WILLIAM STREET RESIDENTIAL

ACCESS DESIGN REVIEW – DEVELOPMENT APPLICATION (DA)

164-172 and 174-194 William Street, Woolloomooloo, NSW

Project number: 119744
Revision: ADR 1.0
Date: 23 September 2025

Sheet No. **Rev**
2000 1

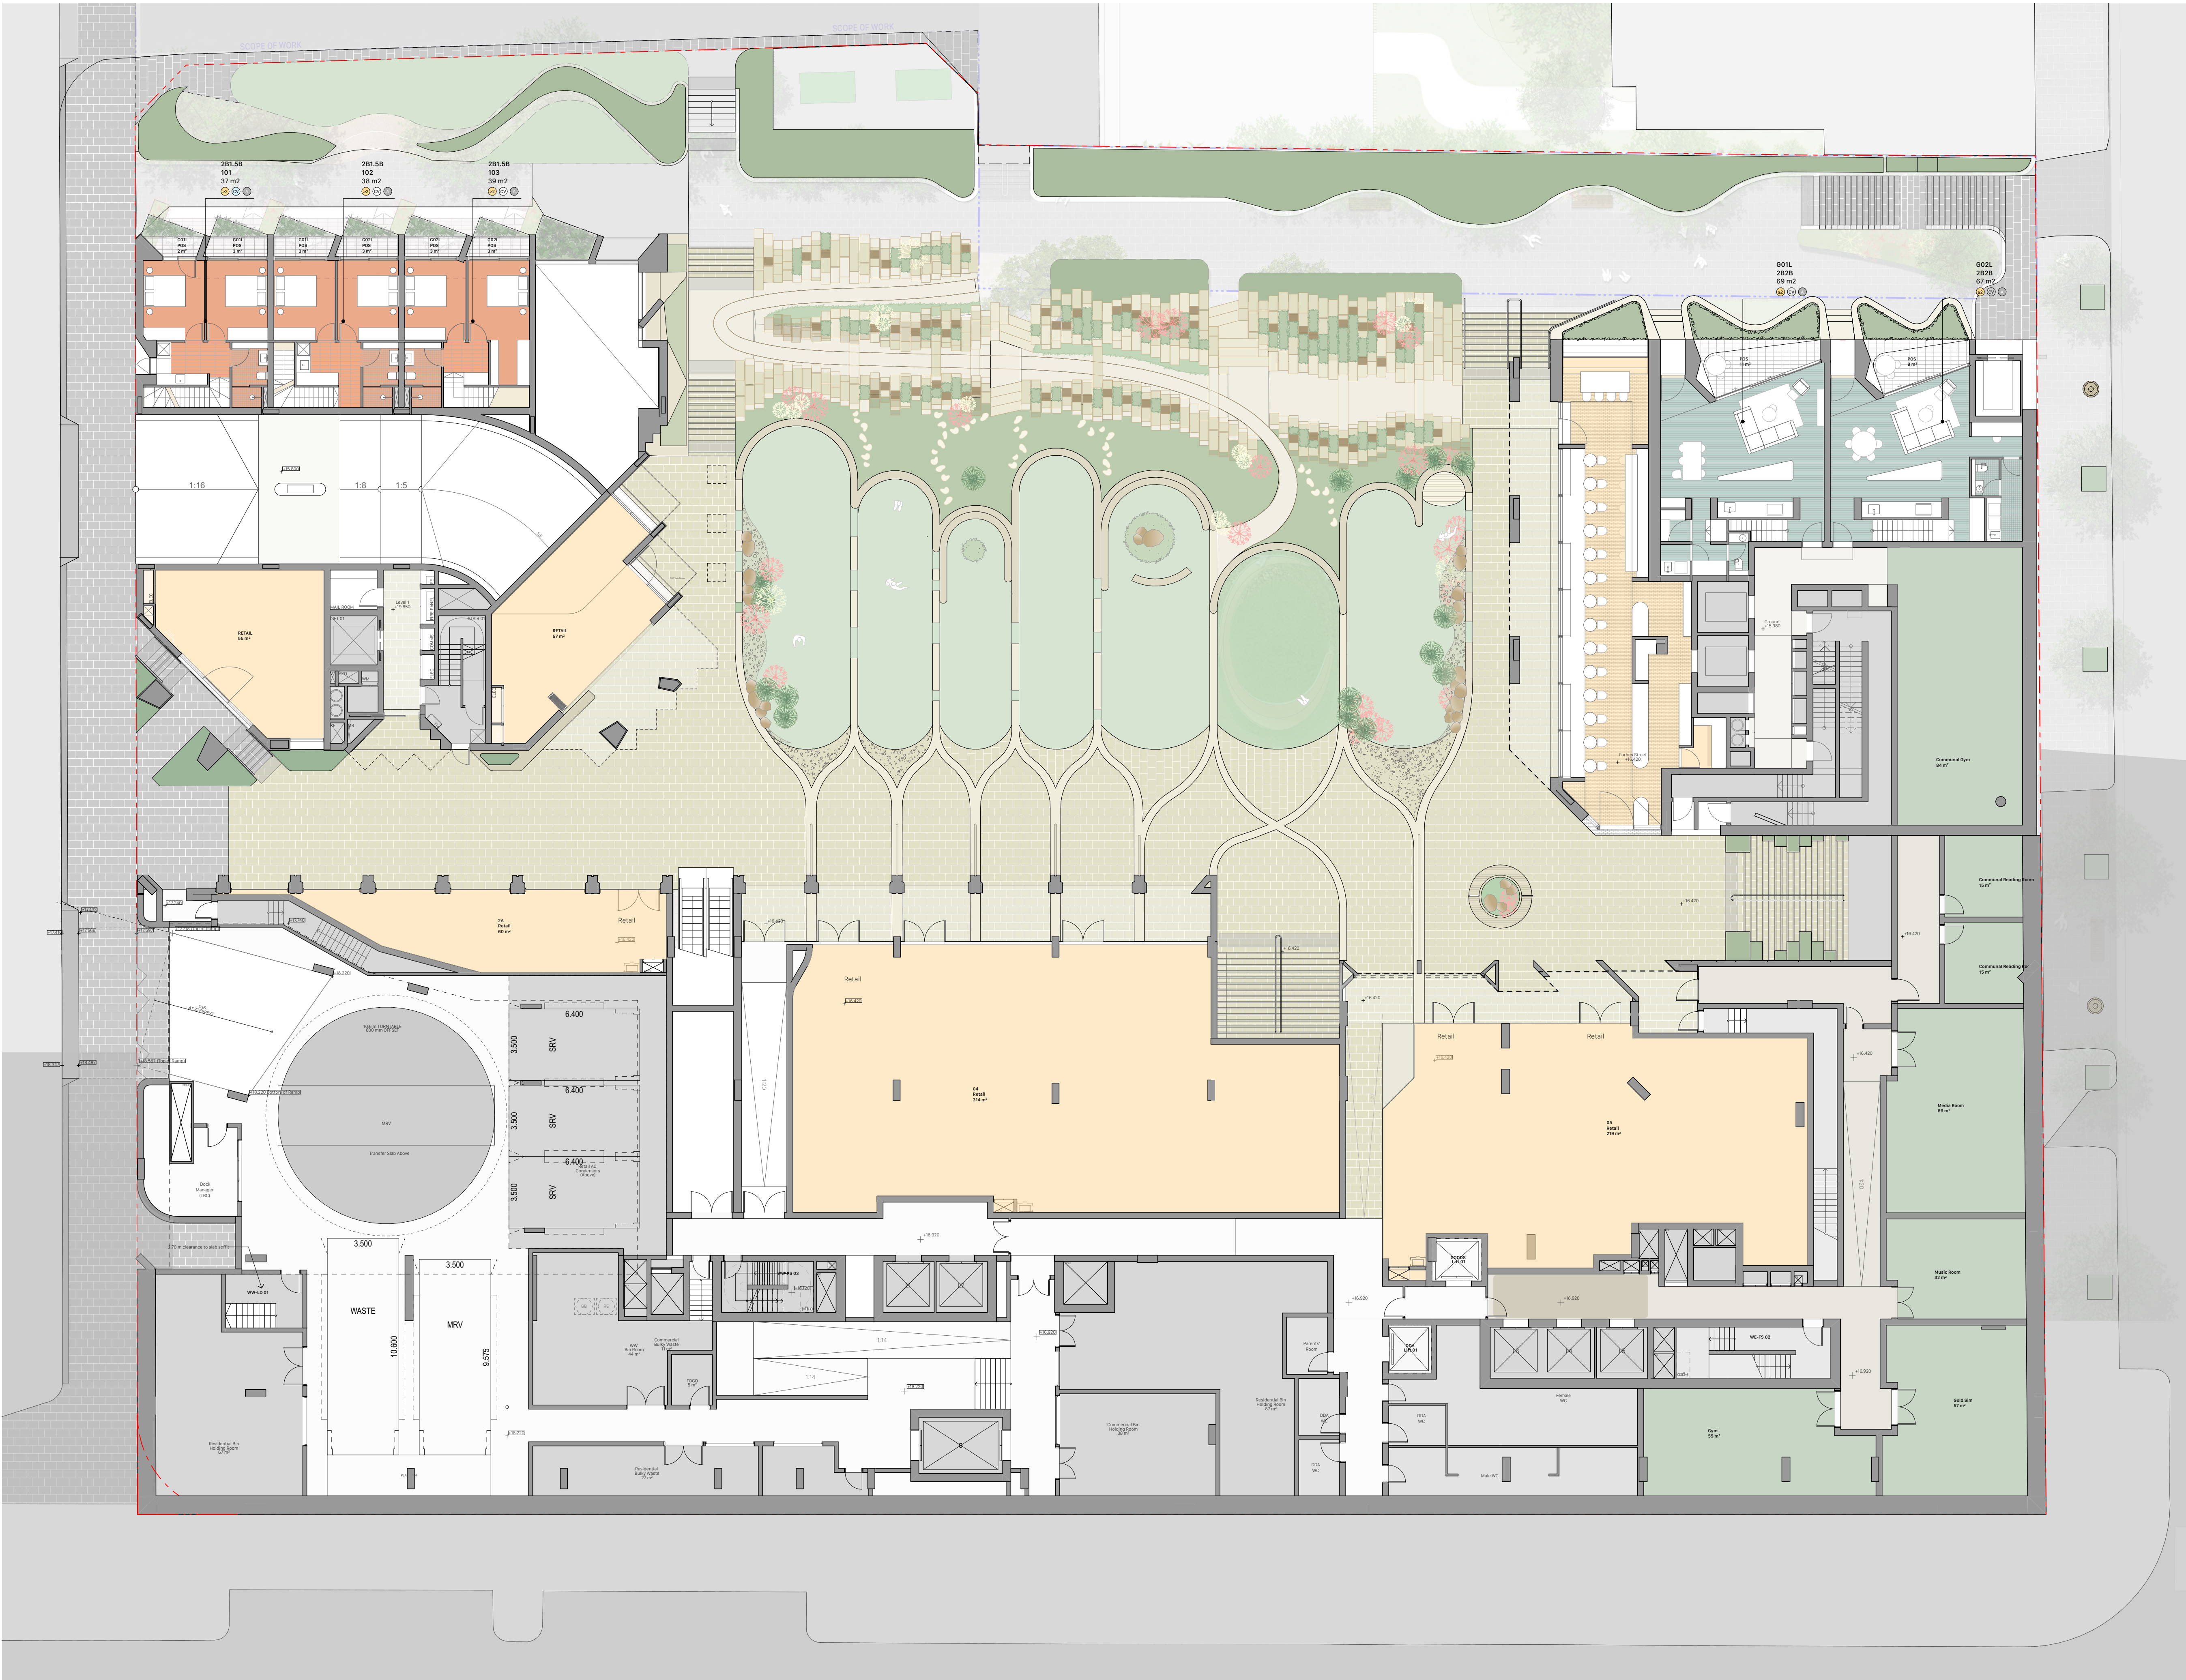
Item	BCA Clause	Relevant Performance Requirement	Technical Requirement	Technical Departure
1.	D4D6	D1P8 Car parking for people with disability Provide, to the degree necessary, to give equitable access for carparking	The bollards in the shared zone to be in accordance with 2890.6:2009. A structural column has been provided in lieu of a bollard.	A structural column in located in front of the shared accessible parking space shared zone.

Item	BCA Clause	Relevant Performance Requirement	Technical Requirement	Technical Departure
			Column hindering in the shared zone and hence required to be relocated. Alternatively, a performance solution may be provided
